RE: **3545 Princeton Drive NE**
Building Addition
Grading and Drainage Plan
Engineer's Stamp Date 7-28-16 (File: G16D152)

Re: Winnelson Wake House Remodel Addition
3545 Princeton Dr NE
Traffic Circulation Layout
Architect's Stamp dated 09-26-16 (G16D152)

Re: Winnelson Wake House Remodel Addition
3545 Princeton Dr NE
Traffic Circulation Layout
Architect's Stamp 09-26-16 (G16D152)

TCL PLAN

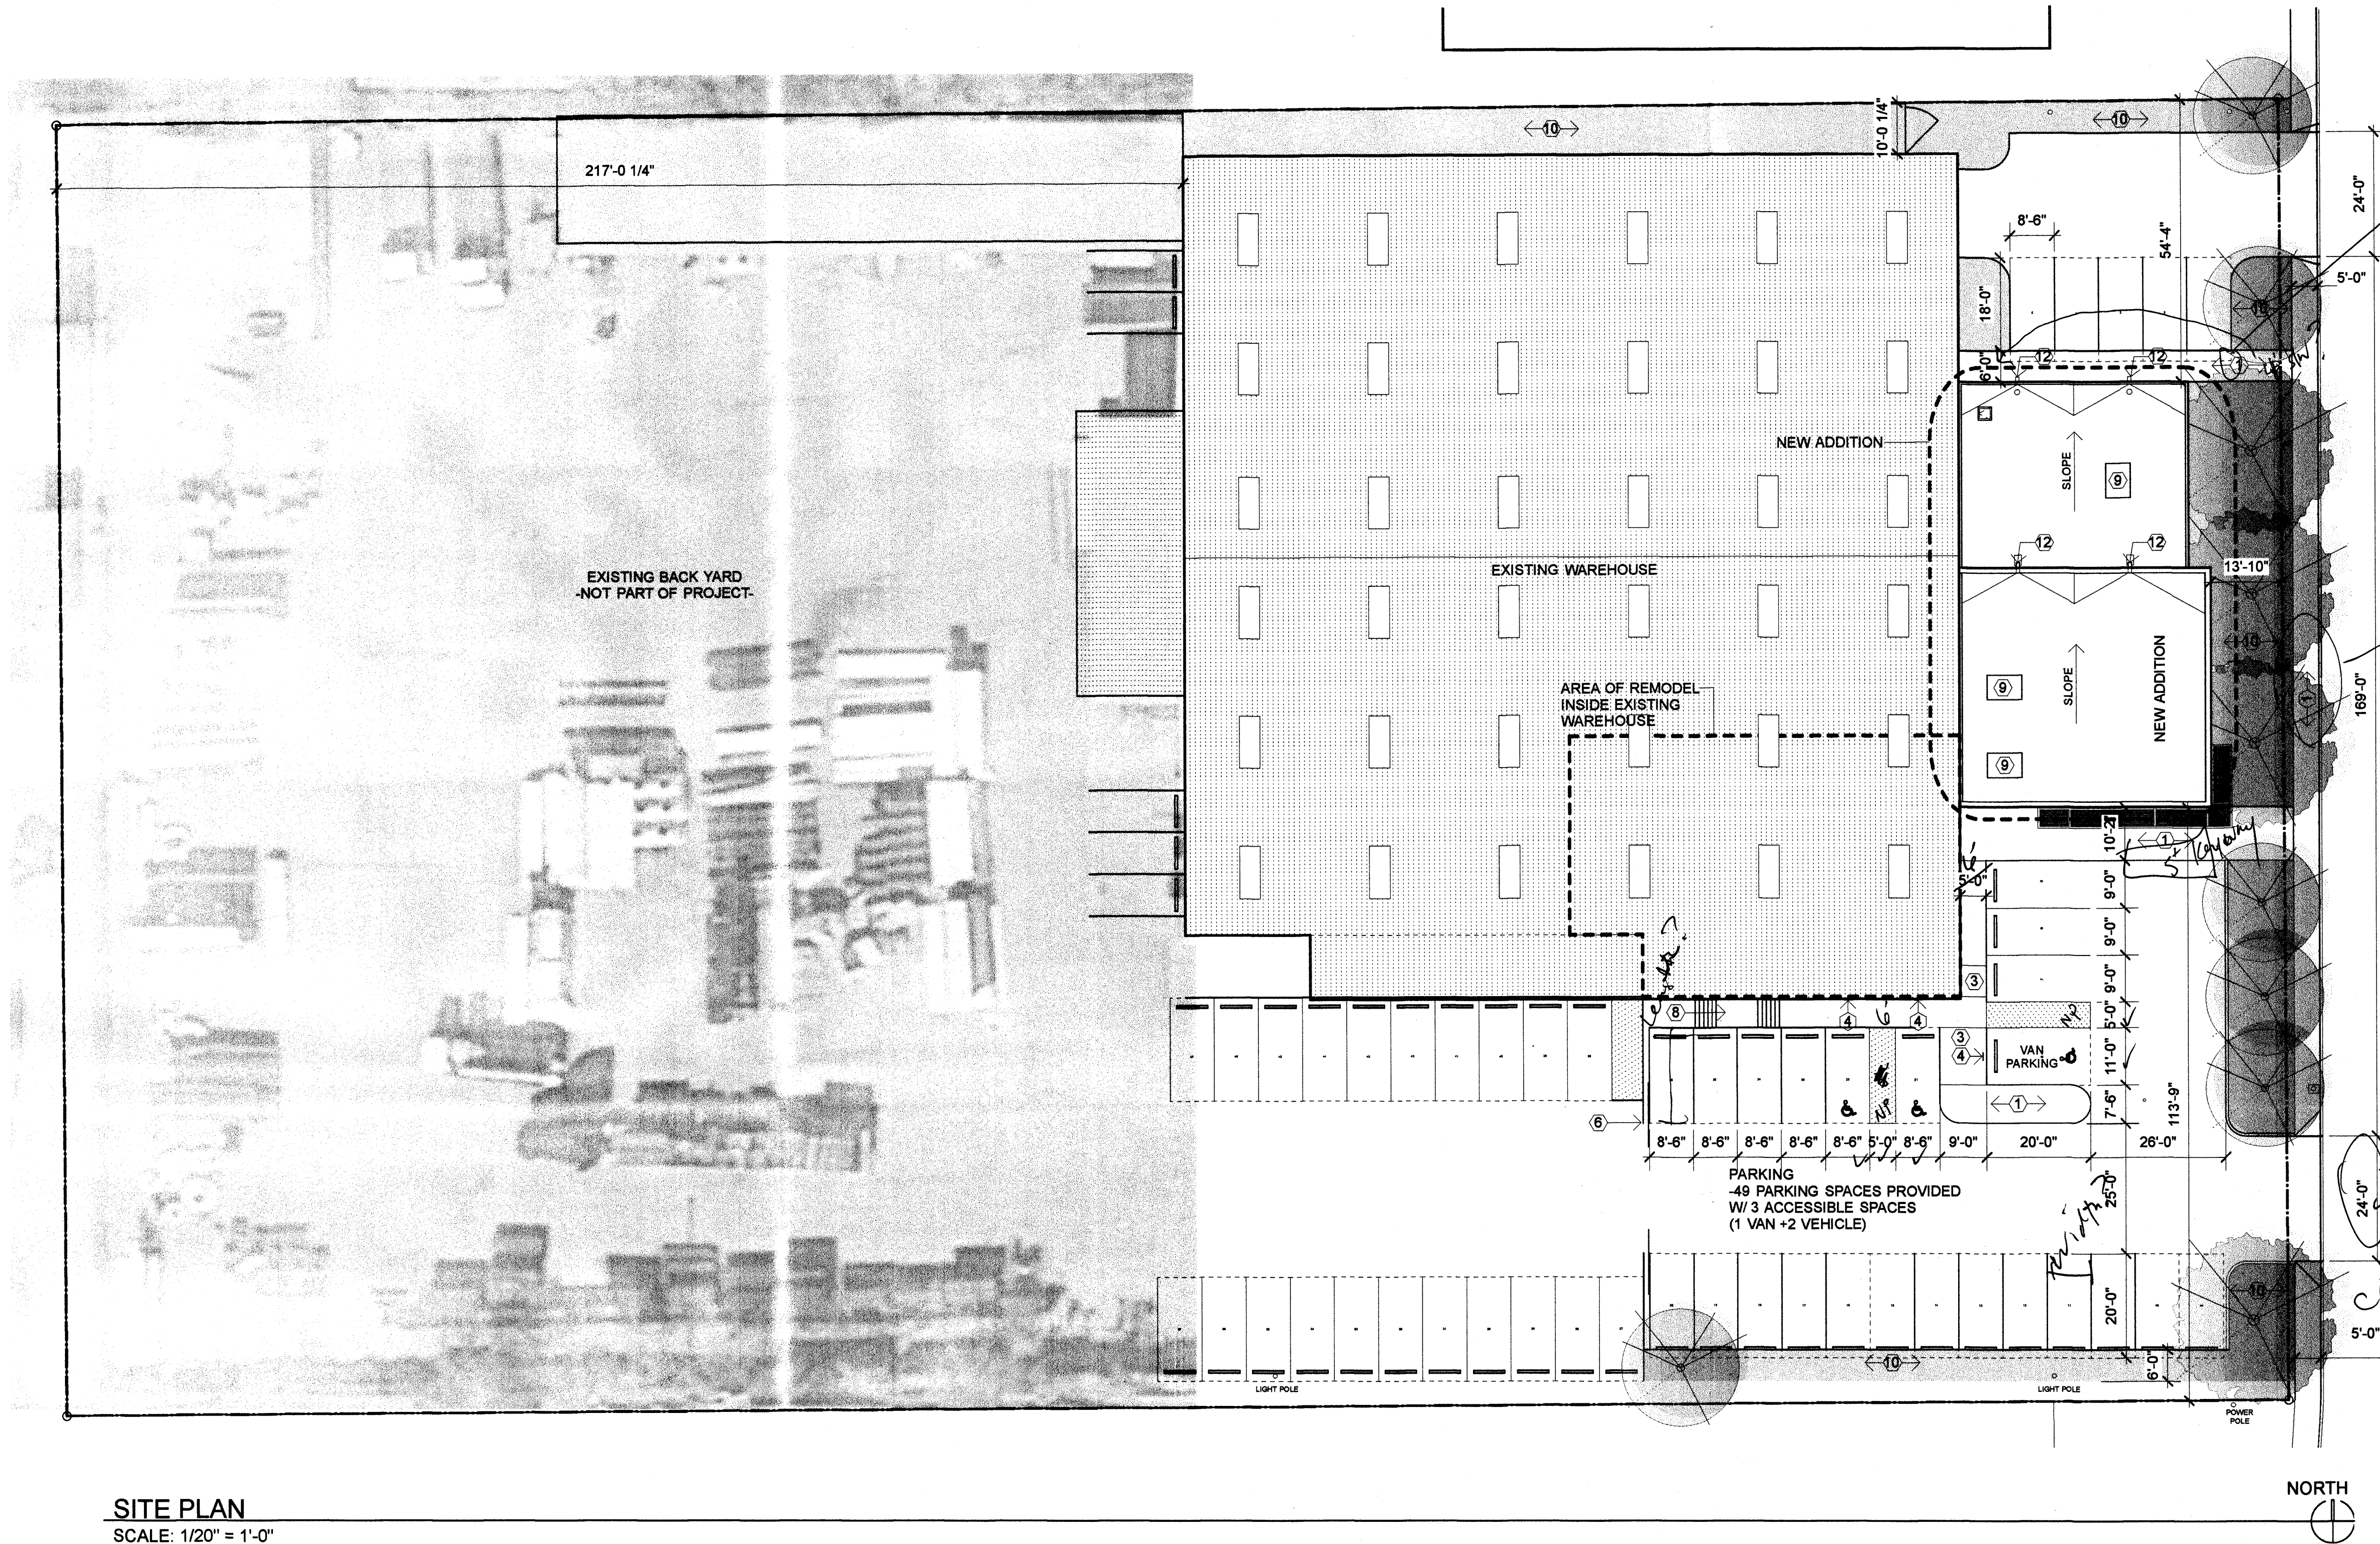
1. Identify the right of way width and label on Princeton Dr NE.
2. Please list the width and length for all existing and proposed parking spaces. Some dimensions are not shown.

3. The ADA access aisles shall have the words **"NO PARKING"** in capital letters, each of which shall be at least one foot high and at least two inches wide, placed at the rear of the parking space so as to be close to where an adjacent vehicle's rear tire would be placed. (66-1-4.1.B NMSA 1978)

4. A 5 ft. keyway is required for dead-end parking aisles.
5. Per DPM, a 6 ft. wide ADA accessible pedestrian pathway is required from the HC parking stall access aisles to the building entrances. Please clearly show this pathway and provide details.

6. Call out where motorcycle parking and bicycle parking is located on site plan.
7. All sidewalks along streets should be placed at the property line.
8. Show the clear sight triangle and add the following note to the plan:
"Landscaping and signage will not interfere with clear sight requirements. Therefore, signs, walls, trees, and shrubbery between 3 and 8 feet tall (as measured from the gutter pan) will not be acceptable in the clear sight triangle.

9. Unused curb cuts must be replaced with sidewalk and curb & gutter. A build note must be provided referring to the appropriate City Standard drawing.

10. Please specify the City Standard Drawing Number when applicable.
11. Please include two copies of the traffic circulation layout at the next submittal.
